One Earth Solar Farm

Draft Statement of Common Ground with West Lindsey District Council

EN010159/APP/8.4.24

August-October 2025

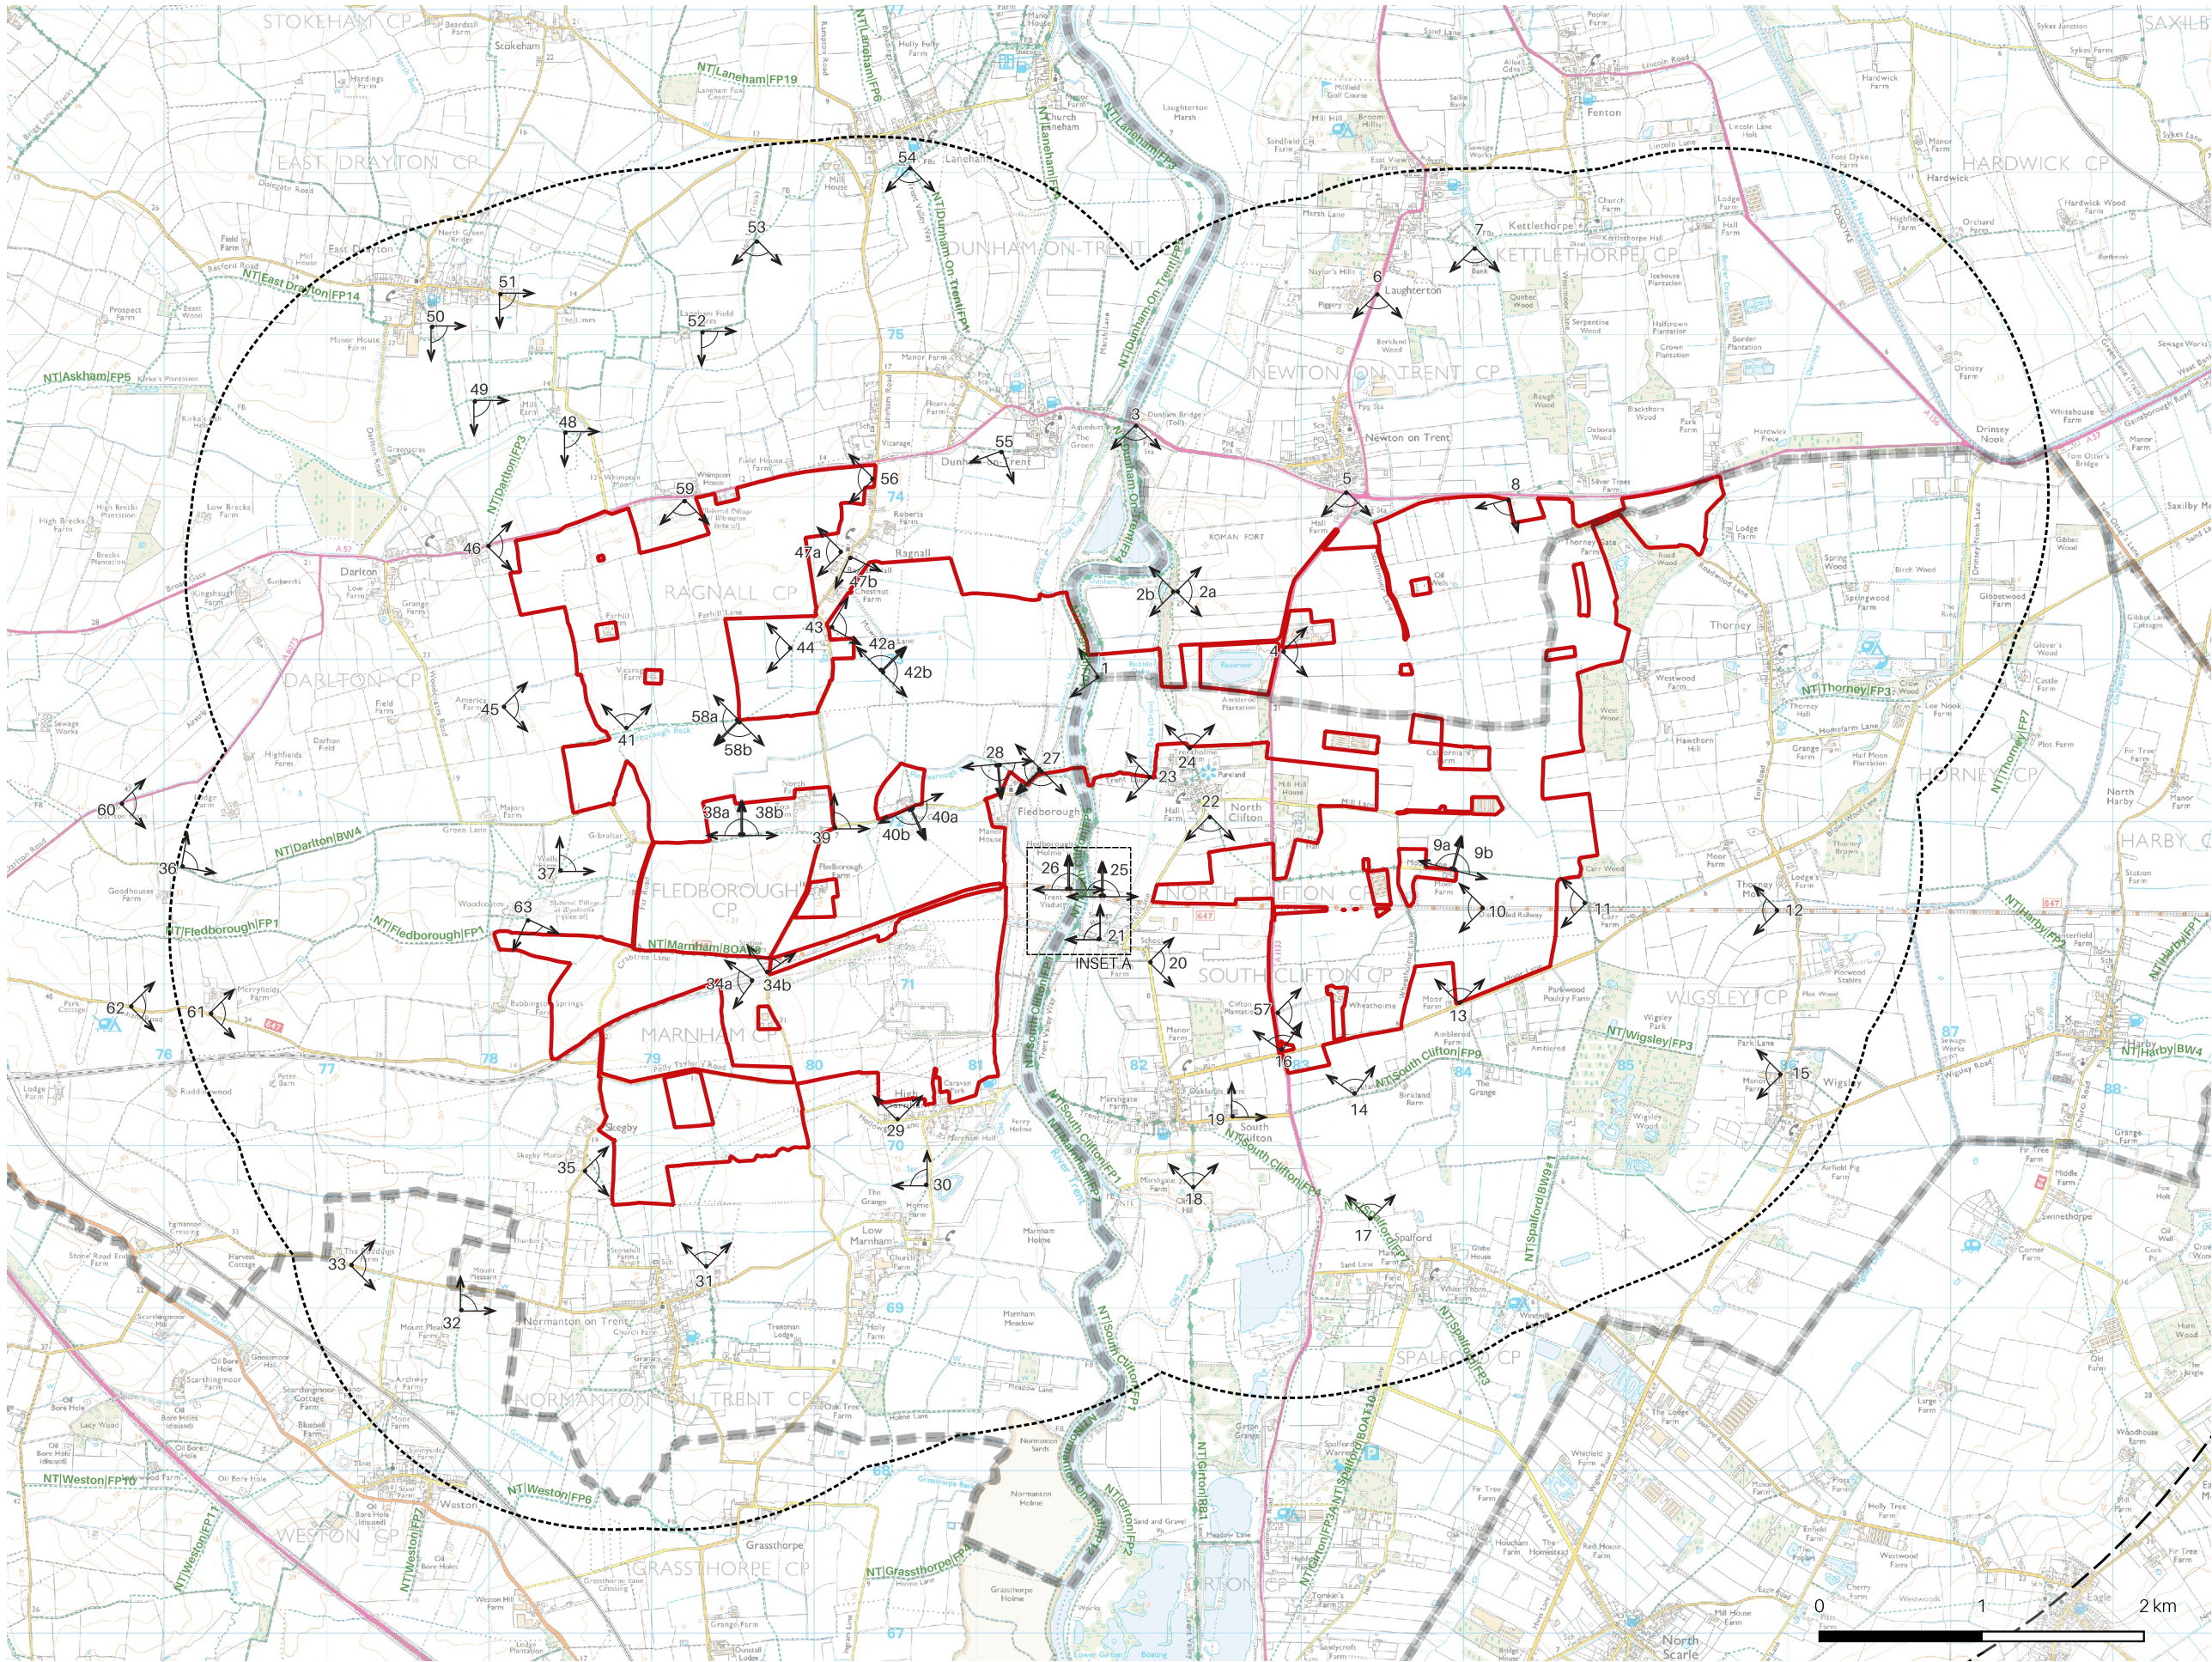
045-12	<u>Glint and Glare mitigation fencing – Viewpoint 4</u>	<p><u>West Lindsey District Council questioned the close board fencing shown in Viewpoint 4. Further clarity was requested around the purpose of this fencing, its extent, and anticipated duration before the adjacent vegetation would be established such that the requirement for the fencing would be no longer required. Raised a query around the purpose for the wooden fencing demonstrated in</u></p>	<p><u>Discussions remain on-going regarding the assumptions on the glint and glare fencing in terms of its extent and duration.</u></p> <p><u>The applicant provided clarification in its response to the related action point from ISH2 [REP3-065]. The applicant will provide further clarification in its response to the related action point from ISH2The</u></p>	Under discussion

<p>Viewpoint 4. Further clarity requested around the extent of this fencing, and the length of time if it is temporary.</p> <p><u>WLDC await clarity on the proposed fencing mitigation which we understand will be submitted at deadline 4.</u></p>	<p>applicant will provide further clarifications ahead of Deadline 2.</p>	
--	--	---	--	--
